**WELWYN HATFIELD BOROUGH COUNCIL
EXECUTIVE DIRECTOR - PLANNING, PUBLIC PROTECTION AND GOVERNANCE**

DELEGATED APPLICATION

Application No: 6/2020/2621/FULL
Location: Woodside House Bridge Road Welwyn Garden City AL8 6UJ
Proposal: Replacement of 417 windows, 289 like-for-like and 128 modified for strength purposes. 9 PVCu French Door sets and one Fire Exit door.
Officer: Mrs Kerrie Charles

Recommendation: Granted

| Proposed Elevations of Block 5 | |

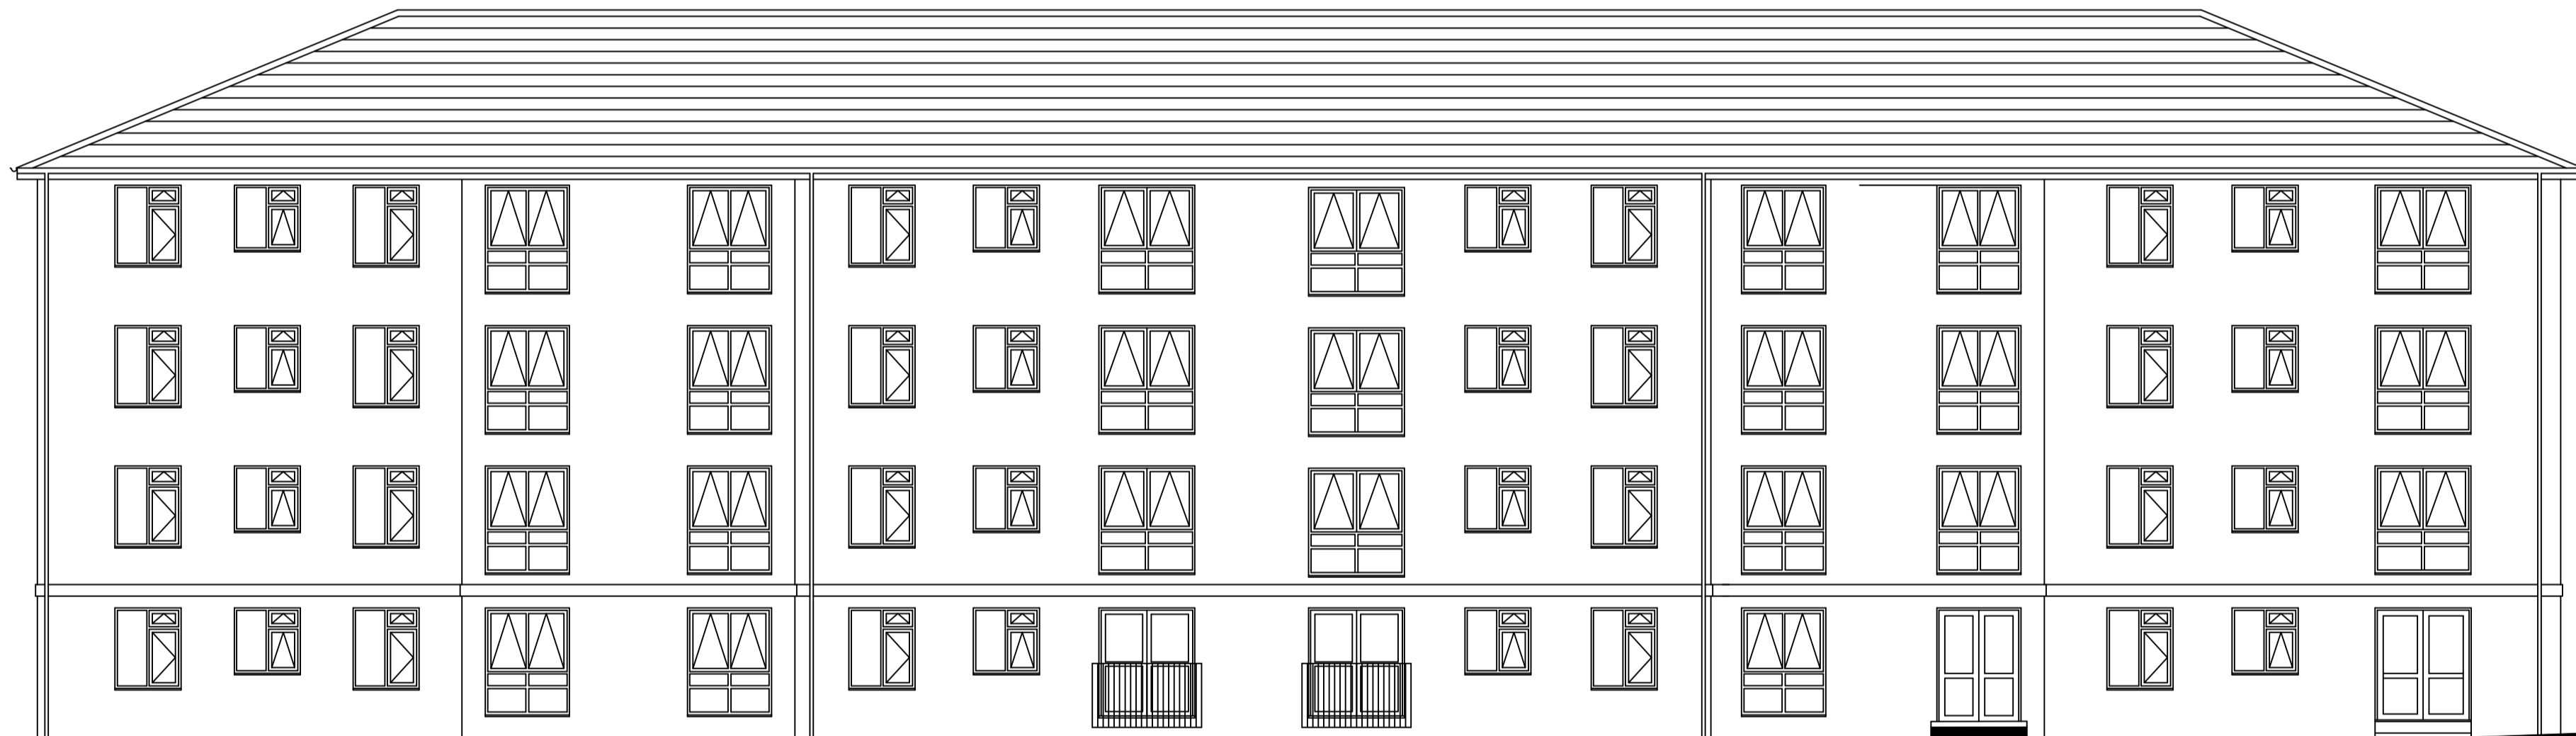
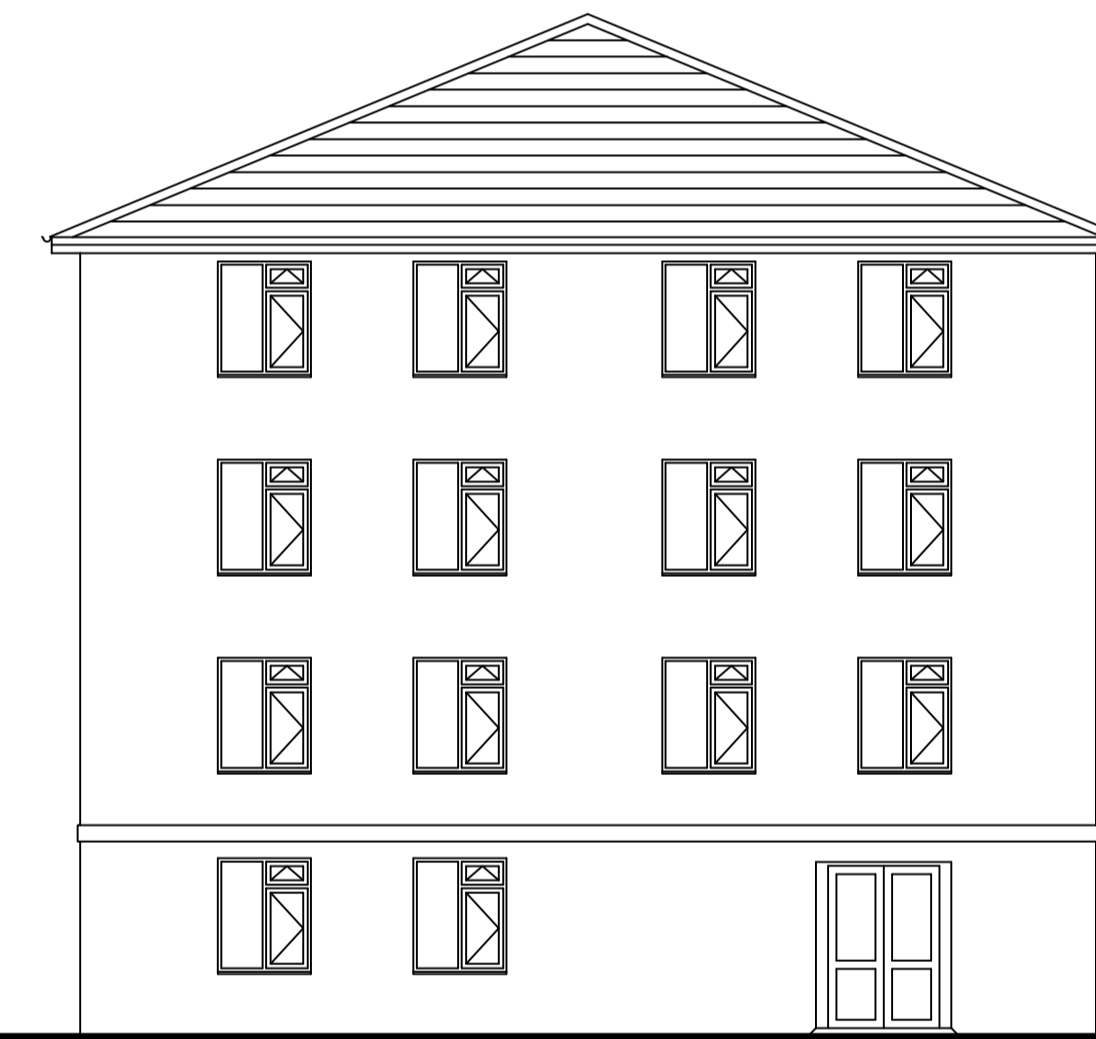
The proposed window replacements would not harm the character and appearance of the conservation area. The fenestration pattern would remain of similar appearance as the existing and therefore there is no additional harm from the proposal

The details supplied with the application states that the replacement windows would be white in colour. In order to preserve the character and appearance of the conservation area, a condition is recommended to ensure the replacement windows are white.

1. The external window frames, glazing bars, sills, other external decorations associated with the window fenestration hereby approved, and the fascia cladding and repairs to porch timberwork shall not be any colour other than white. All other external alterations must match the existing buildings in relation to colour and texture.
